**RFI**

RFI #: 61  
Date: 2/22/2012  
Job: EB-02 Kotler Springs Lofts  
Phone: 877-777-5115

Subject: Fire Extinguisher Cabinets Locations

Drawing: 3.1A, 3.2A, 3.3A, 3.4A, 3.4F

SHEET NUMBER
3.2A
BLDG PLAN 'A'

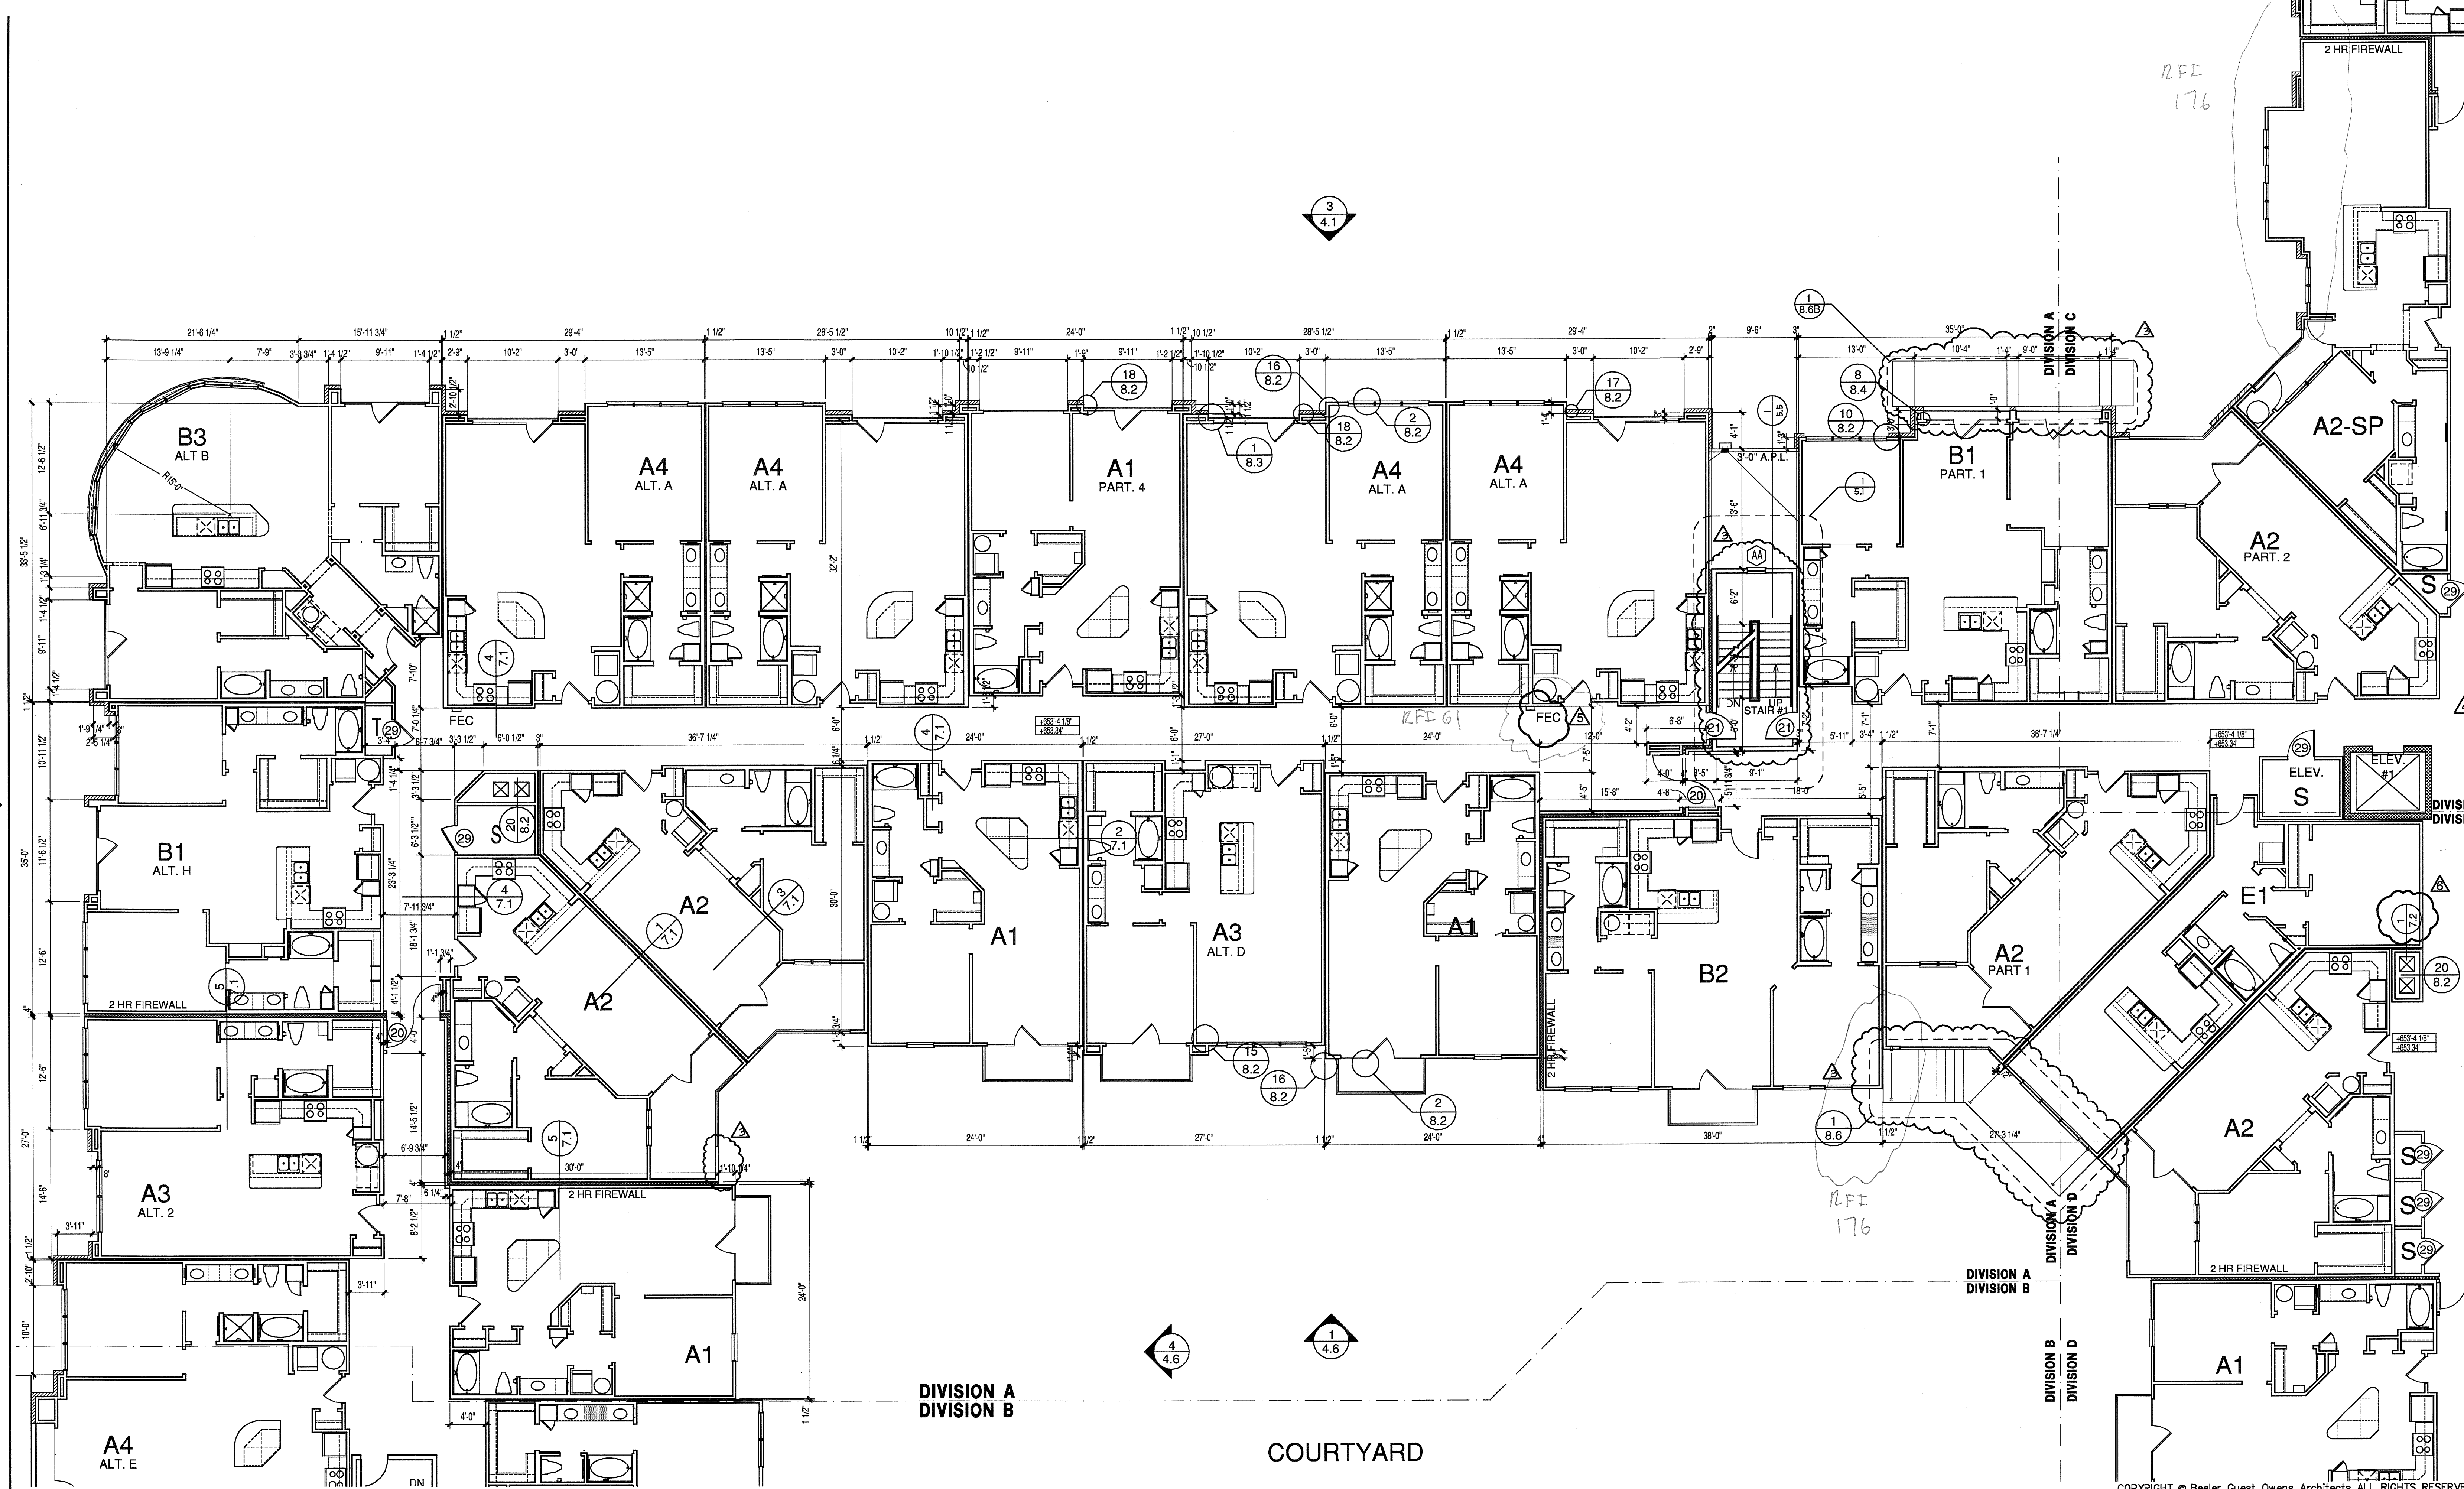
1) There are some inconsistency's with plans for FEC locations in corridors.

3.2A shows 1 FEC

Do you want 2nd FEC added for 2nd & 3rd floors?

1- Yes.

| SHEET NUMBER | 3.4F |

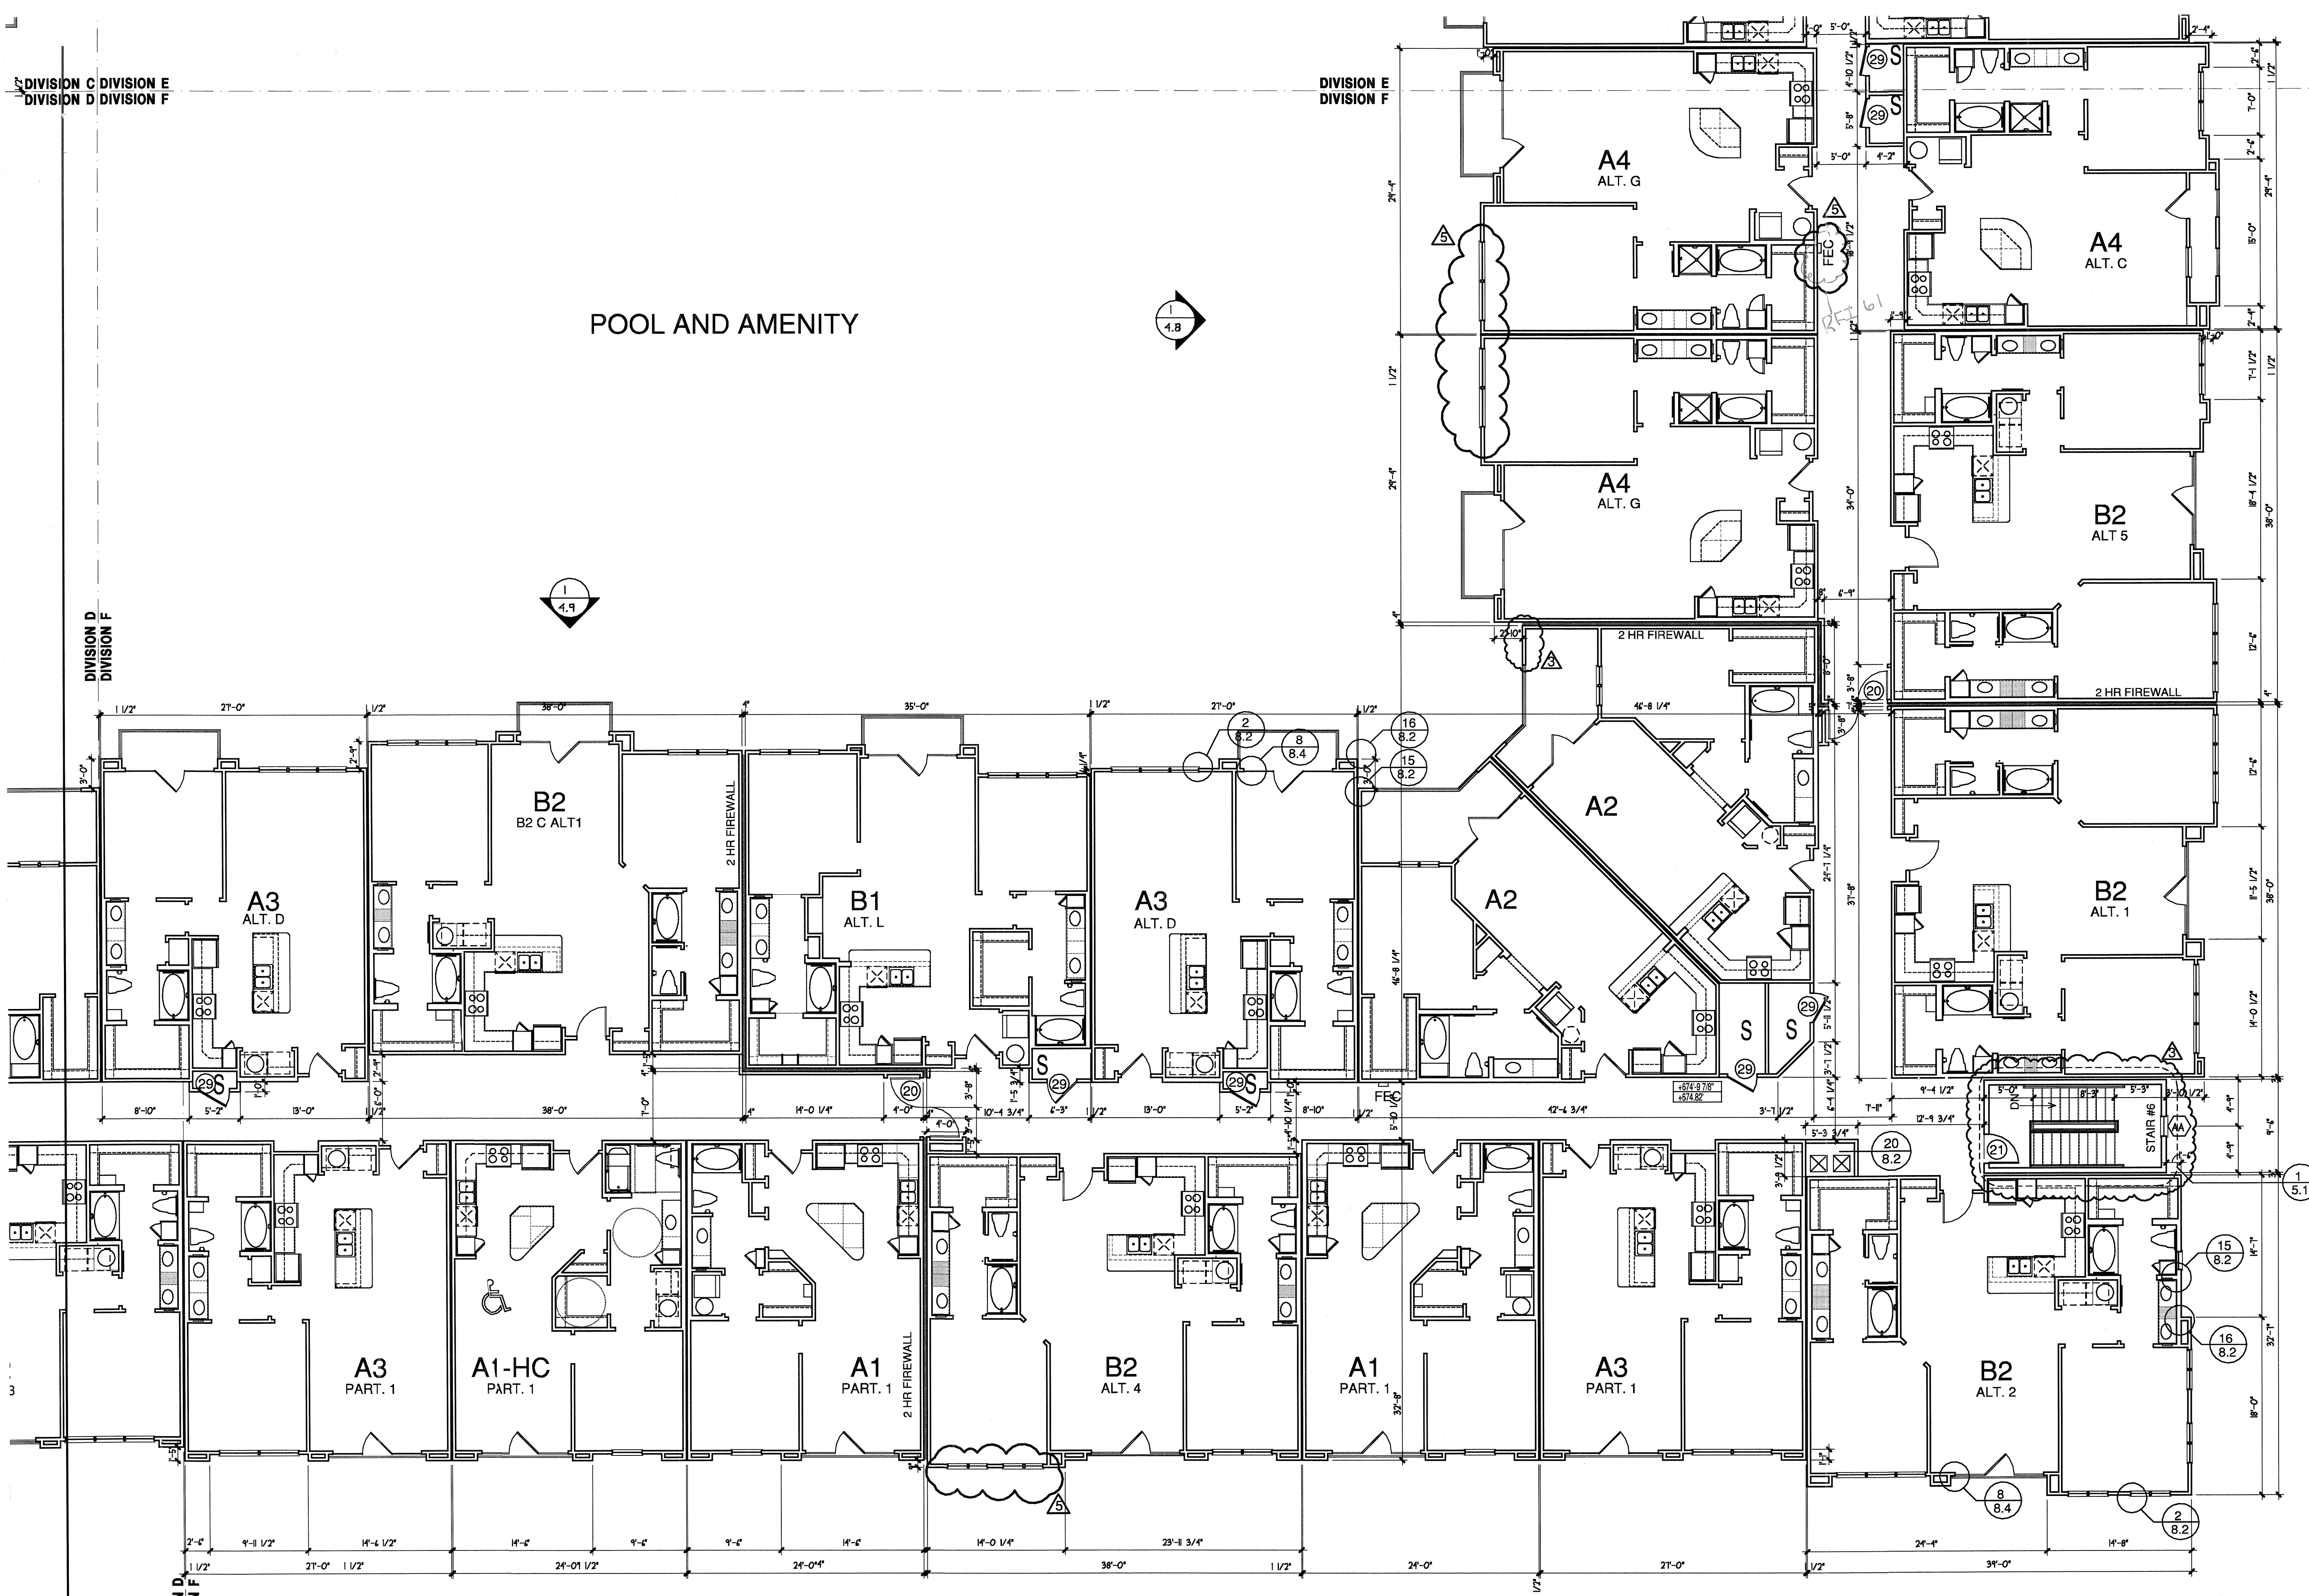
2) On sheet 3.4F - FEC mark is missing on A4 Alt G wall.

The FEC is shown on 1st, 2nd and 3rd floors, does the FEC need to be included at 4th floor?

2- Yes. I've checked all locations and the one's you mentioned are the only problem locations. I adjusted 2 other FEC locations by moving them a foot or so now all FECs line up in the same spot from floor to floor (except for the Club and Garage areas).
